**WELWYN HATFIELD COUNCIL – DEVELOPMENT CONTROL**  
**DELEGATED REPORT**

<b>APPLICATION No:</b>	<b>N6/2012/0692/FP</b>
<b>APPLICATION Site:</b>	<b>6 Fordwich Road, Welwyn Garden City</b>

The proposal is a full planning application for the erection of a single storey side and rear extension. This will provide a (4<sup>th</sup>) bedroom, shower room and Utility Room to the side of the dwelling; and, a dining room across the full-width of the rear elevation.

**DRAWING TITLE**  
PROPOSED SINGLE STOREY SIDE  
AND REAR EXTENSIONS

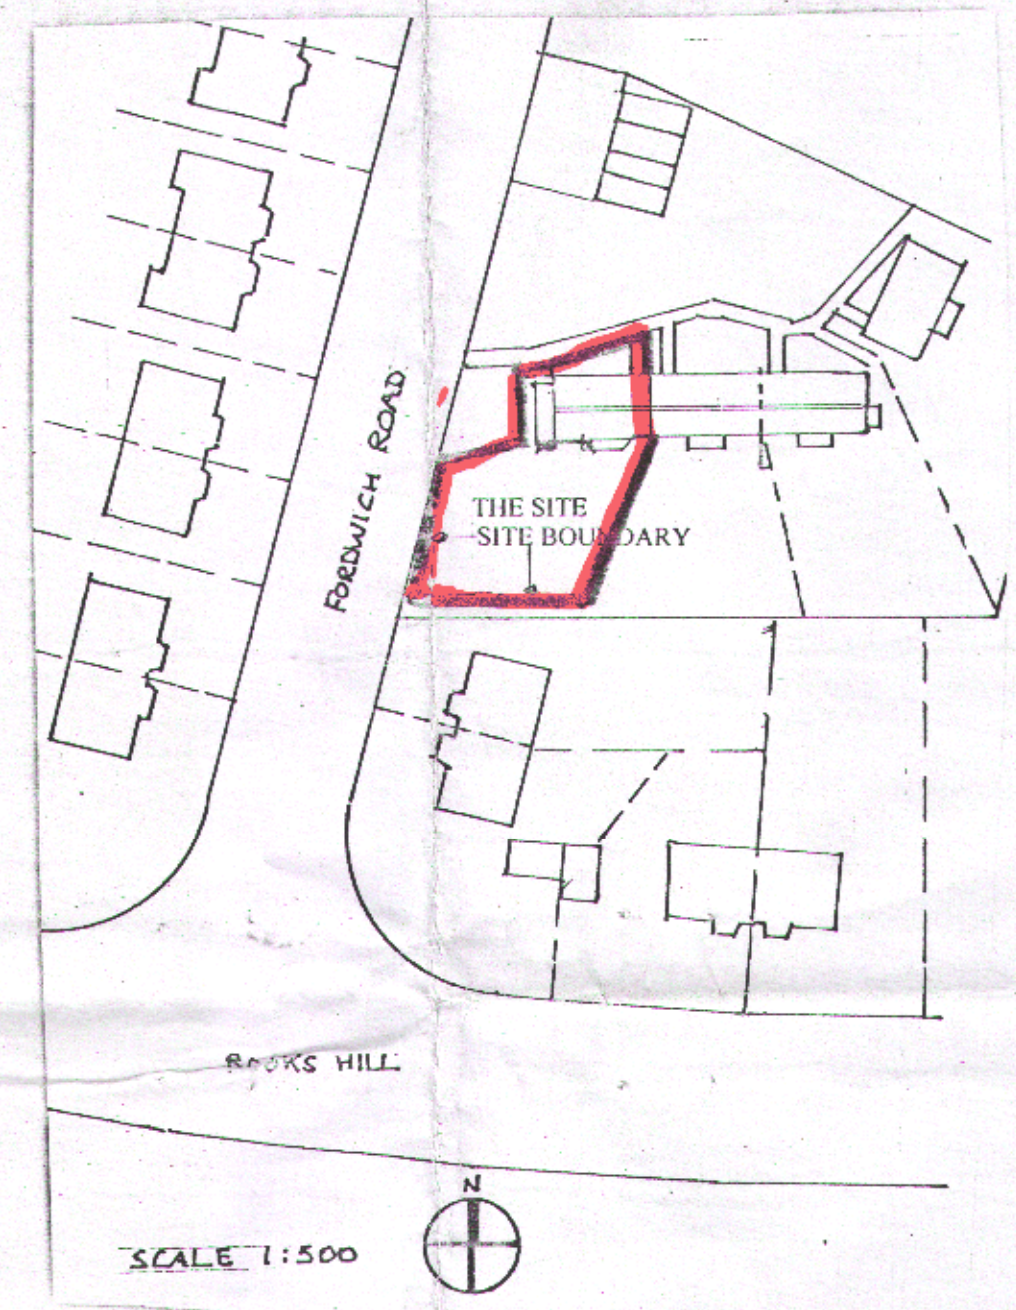
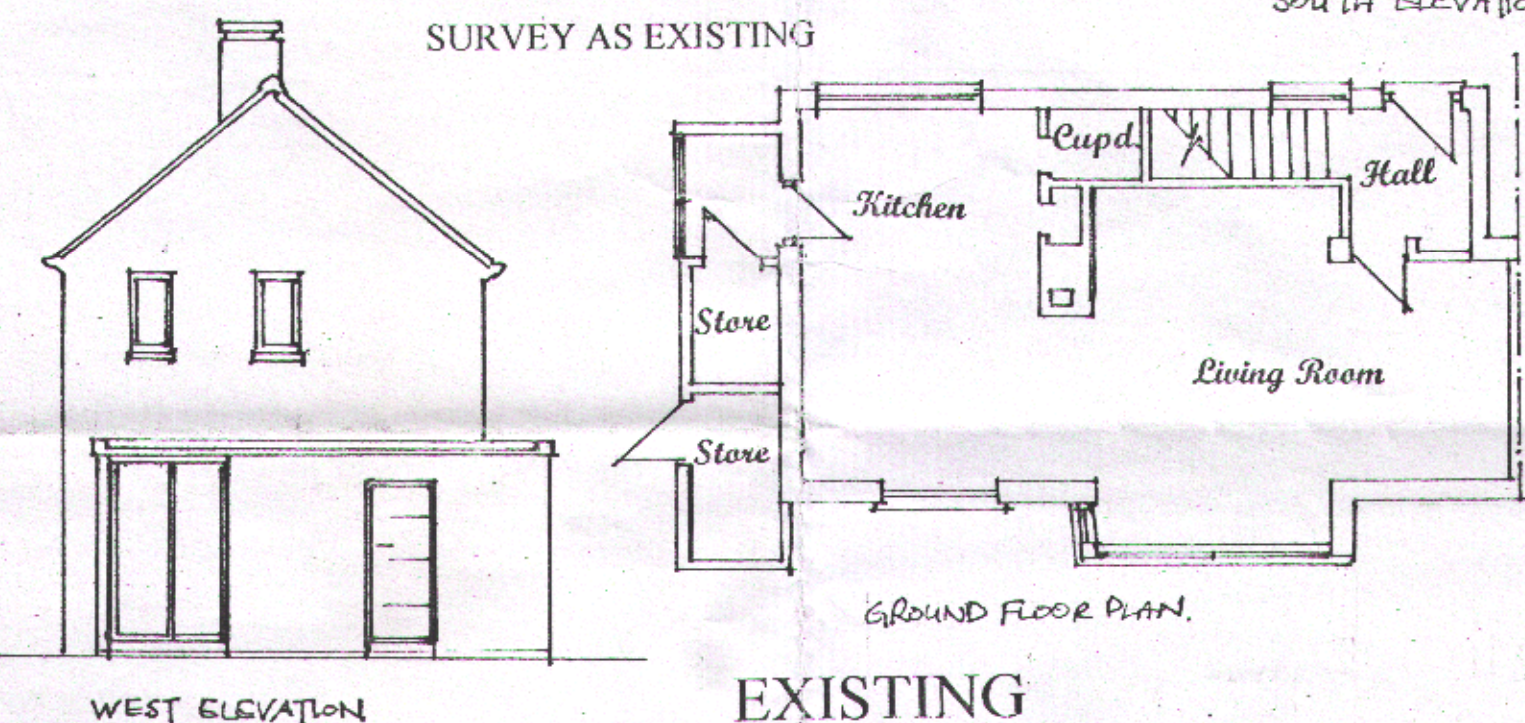
The proposed extensions follow a refusal in 2006. The current extensions are in fact, larger than the previous refusal due to the single storey rear extensions, although the side extension has been reduced in width by 1m. The form of the extension is similar to many single storey extensions on the side of end of terrace dwellings within the town. Although larger, the rear extension is not an issue because it would be screened by a large 1.8m Beech hedge that exists on the side boundary. Therefore the most prominent section would be the side extension when viewed from the north and immediately to side of the site. There is an existing single storey side section but this is only c.1m wide. The extension would be screened by an existing tree and shrubbery on the open frontage area to the north but part of the extension would be prominent. The applicant has offered to plant a Beech Hedge to mitigate the impact built this would not necessarily serve any useful purpose as the side windows in the extension would mean it would never grow more than 1.2m. However, some landscaping would be beneficial in terms of reducing the impact.

The reduction in width of the extension and the slight reduction in height would reduce the impact, albeit that a single storey side addition has also been added. However, given the location of the Beech hedge to the side, the fact that this would be retained save a small section to allow for the construction of the extension means that the proposal would not be so harmful to the conservation area, subject to additional landscaping is also being proposed that it should be refused on these grounds alone.

The extensions are proposed to be sited to the side and rear of the existing dwelling, and are single storey. The attached adjoining dwelling at No. 8 Fordwich Road shares an angled boundary with No. 6. The proposed rear dining room extension would be 3.0m deep; however, it would be site at an angle away from No. 8 and as such would have a minimal impact on the amenities of occupants of this adjoining dwelling through any loss of light or outlook. No windows are proposed to be inserted in the extension that would face this neighbouring dwelling.

4. No development shall take place until full details on a suitably scaled plan of soft landscape works have been submitted to and approved in writing by the Local Planning Authority. The development shall not be carried out other than in accordance with the approved details unless otherwise agreed in writing by the local planning authority. The landscaping details to be submitted shall include:-
